Review of Stage 1 Safety Audit and Designers Response.

DOMUSEA DEVELOPMENTS PROPOSED RESIDENTIAL DEVELOPMENT THE BOWERIES, BARNHAM ROAD, EASTERGATE STAGE 1 - ROAD SAFETY AUDIT OCTOBER 2019

Review of stage 1 safety audit carried out by Martyn Parr, Mayer Brown during October 2019, and designer's response.

scale 1:250 @ A3 date OCTOBER 2019 drawing number MBSK191001-01	title VISIBILITY SPLAYS AT ACCESS	client DOMUSEA DEVELOPMENTS project THE BOWERIES, BARNHAM ROAD EASTERGATE	drawn by JME checked by AP cad file FIGURES A.DWG rev. D
---	-----------------------------------	---	---

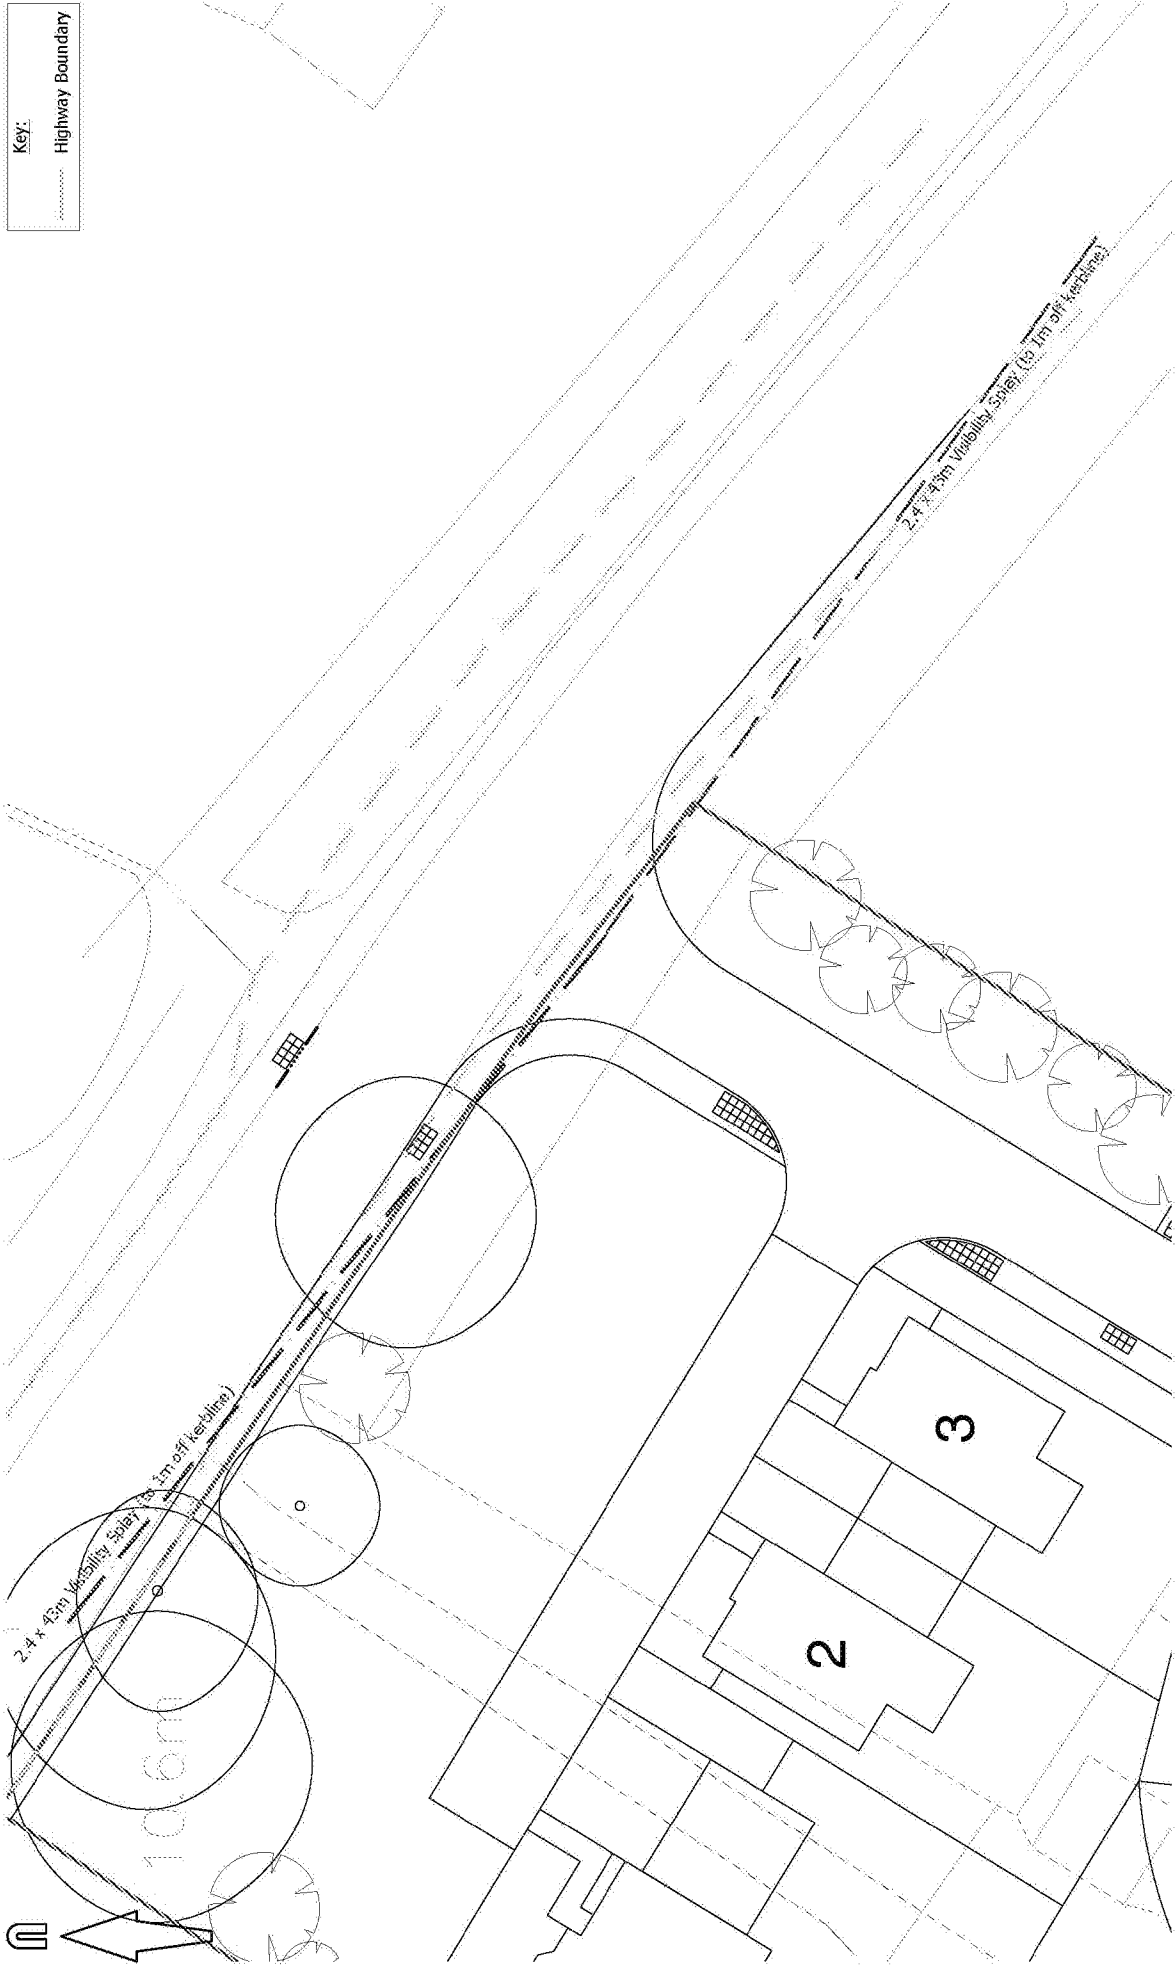
Location: Site Access

Summary: Obstruction to visibility splays

Agree with auditor, this matter can be addressed by way of planning condition.
